Rezoning Transportation Analysis

Petition Number: 2020-068

General Location Identifier: Tax ID. 17514688

Date	Description
05-18-20	First Review
06-28-20	Second Review
09-22-20	Third Review (LJensen)
12-28-20	Fourth Review (LJensen)

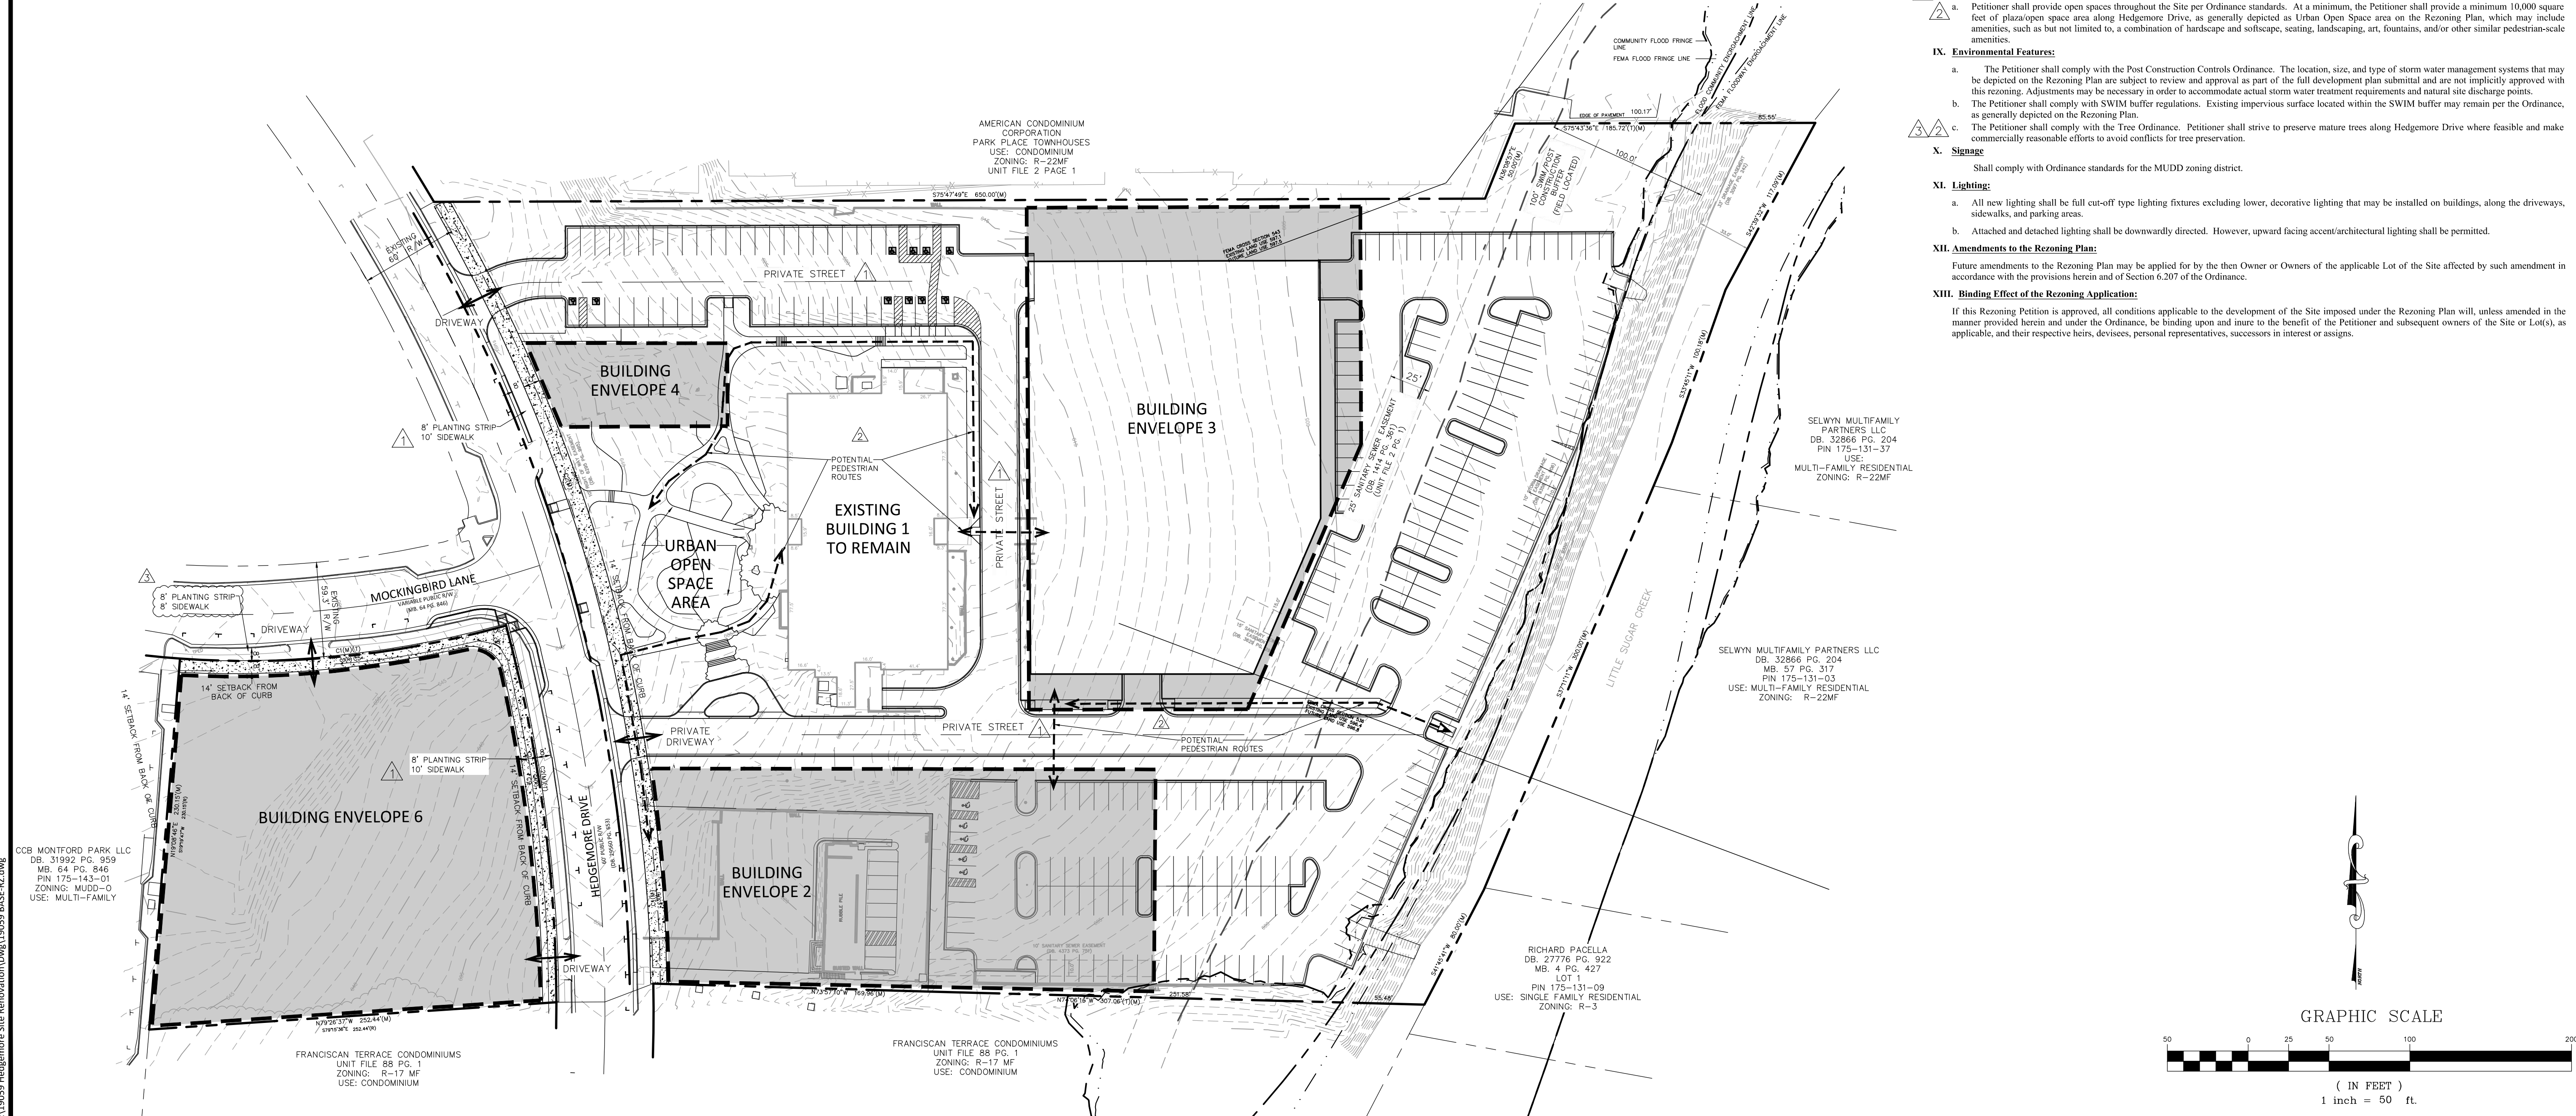
The site is located on Hedgemore Drive and Mockingbird Lane. A Traffic Impact Study (TIS) was approved on January 28, 2021. CDOT is working with the petitioner on a potential connection to the Cross-Charlotte Trail (XCLT), which supports bicycle and pedestrian connectivity throughout the City. The petitioner needs to update the site plan to include the transportation improvements listed under the TIS (once approved), which will need to be inserted under the site conditional notes, V. Transportation, including the XCLT connection once determined.

3. ~~The petitioner should revise the site plan and conditional note(s) to commit to constructing an 8-foot planting strip, and a 10-foot sidewalk on Hedgemore Drive per the Park Woodlawn Area Plan. The site plan should label and dimension both items from the back of curb and gutter to the road centerline.~~
4. **UPDATED per Approved TIS:** ~~CDOT requests that the petitioner revises the site plan and conditional note(s) to commit to a 12' multi-use path connecting Hedgemore Drive to the Cross-Charlotte Trail (XCLT) including a pedestrian bridge over Little Sugar Creek east of the site, to meet the City of Charlotte BIKE Policy. CDOT also requests a public access easement with parking and a trailhead to the XCLT as a Traffic Demand Management (TDM) measure.~~
The petitioner and CDOT will continue to work toward the Cross-Charlotte Trail (XCLT) contributions per the approved TIS.
